DECISION DELEGATED TO HEAD OF PLANNING

Application No: H01-0853-24 **Applicant:** Ark Property

Proposal: Details of full closure report (Condition 13iv of H01-0823-19)

Location: Land Off Stonegate Cowbit Spalding

Site Plan

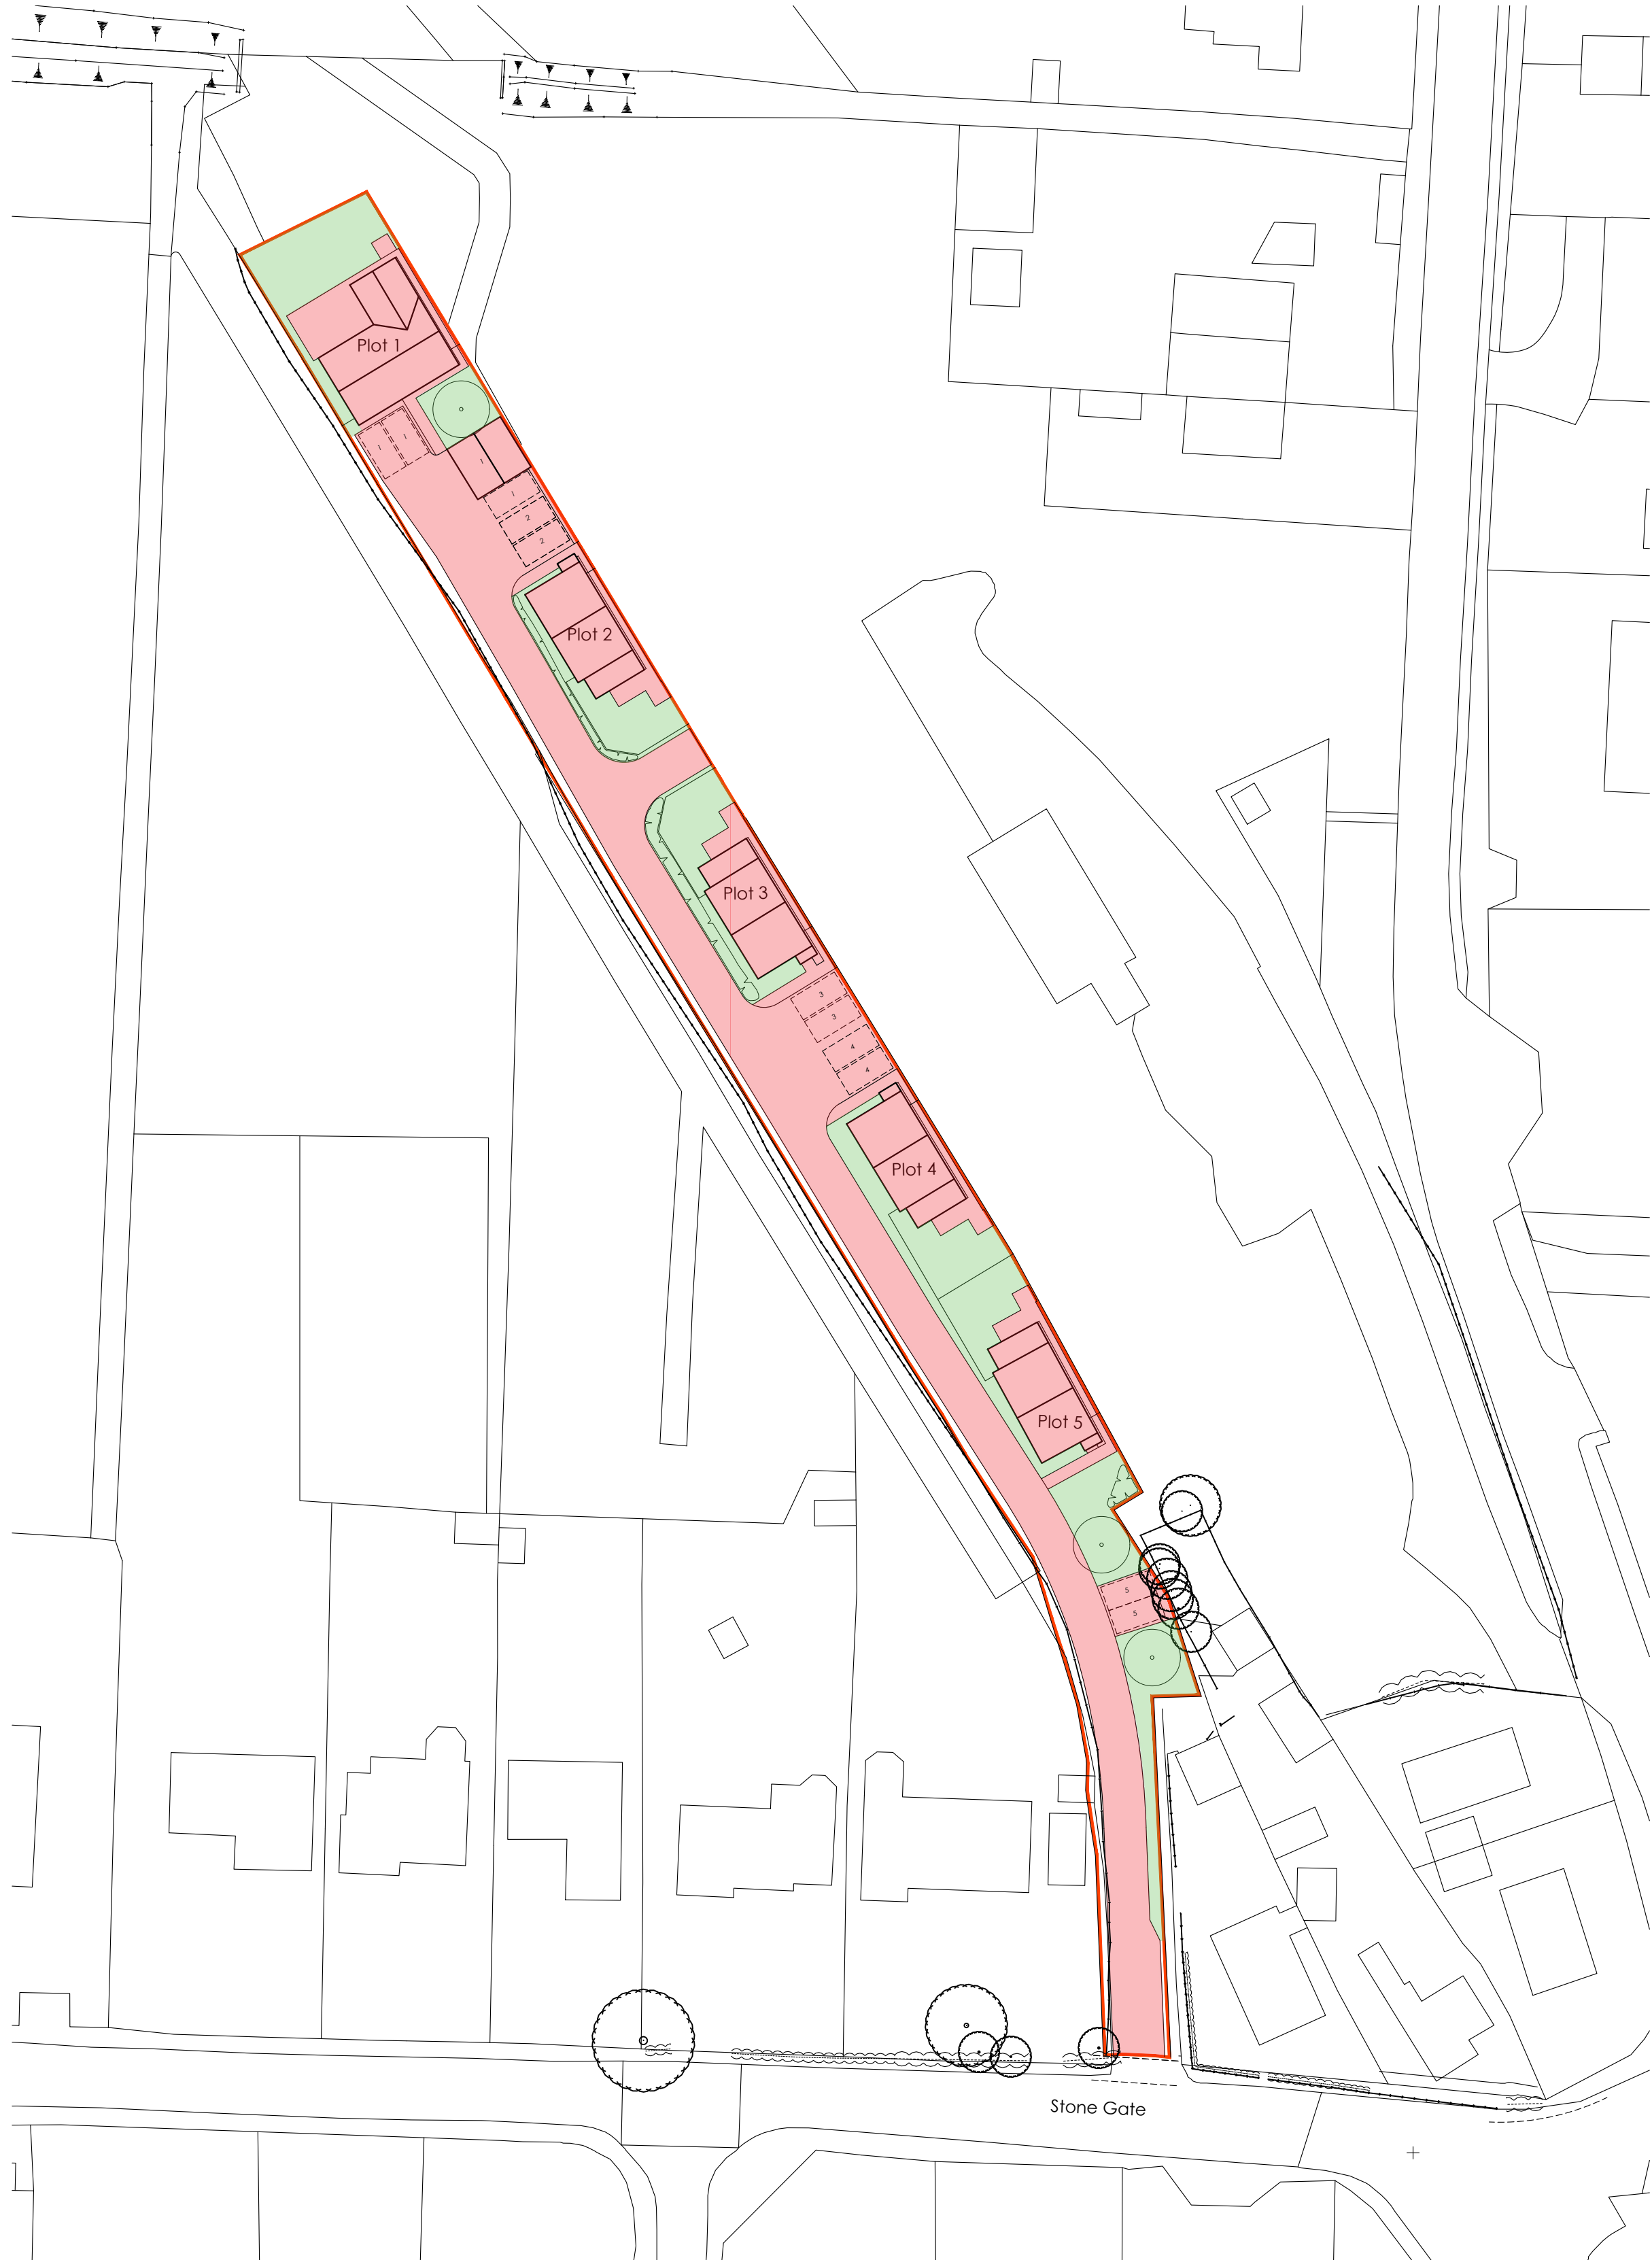
"Following review of the retrospective ground gas mitigation design strategy for plots 1 and 2, I would have no further comments to make. Following review of the verification statement dated 8th October 2024 I wish to see evidence that depths of clean soils imported soils in garden areas of plots 1-5 are at a depth of at 600mm above the capping layer. I would also like to see evidence of the amount of soil imported to site and chemical test data for this imported soil"

"I have reviewed the photos submitted showing the top soil levels are at least 600mm as stated in the remediation strategy and find this acceptable. I have also reviewed the topsoil certificates and find these to be satisfactory. After review these document with the retrospective ground gas mitigation design strategy & 3rd party inspection, testing and validation report by Membrane Testing Solutions and the verification statement by Studio 11 Architecture Limited and agree with the findings. I therefore would like to discharge condition 13 (iv)"
